Application # 1850044348

COUNTY OF HARNETT RESIDENTIAL LAND USE APPLICATION  
Central Permitting 108 E. Front Street, Lillington, NC 27546 Phone: (910) 893-7525 ext:2 Fax: (910) 893-2793 www.harnett.org/permits

- Addition/Accessory/Other: (Size 16 x 40) Use: Inground Swimming Pool Closets in addition? ( ) yes ( ) no

1386 Warren Rd.  
Erwin, NC. 28339.

revised plan  
7/13/18

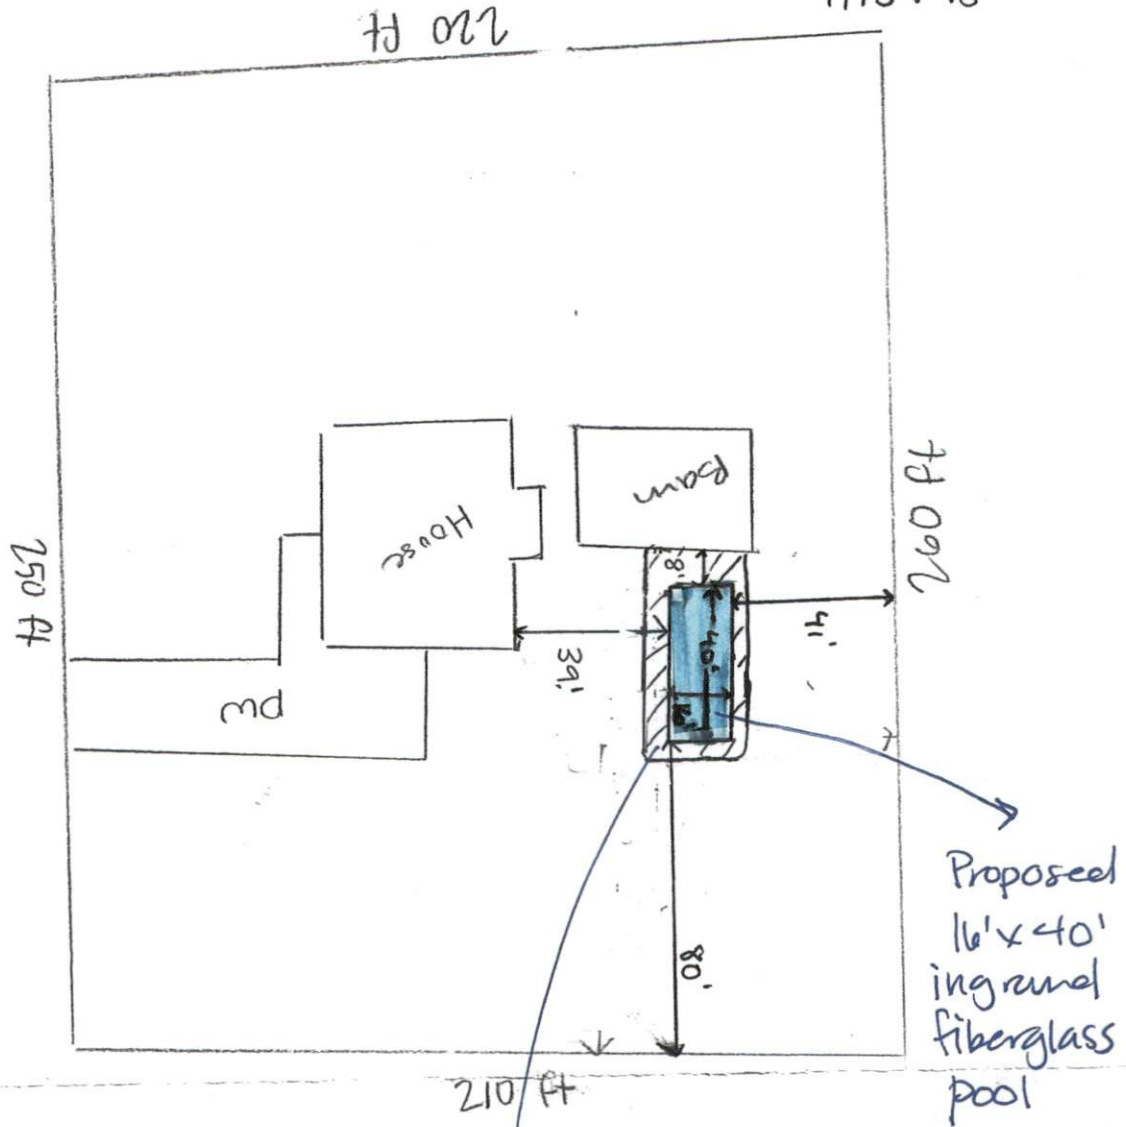
- \* Proposed pool shall be 15<sup>(MIN)</sup> FT from existing drainfield (Flagged onsite)
- [Revision Required - No Fee]
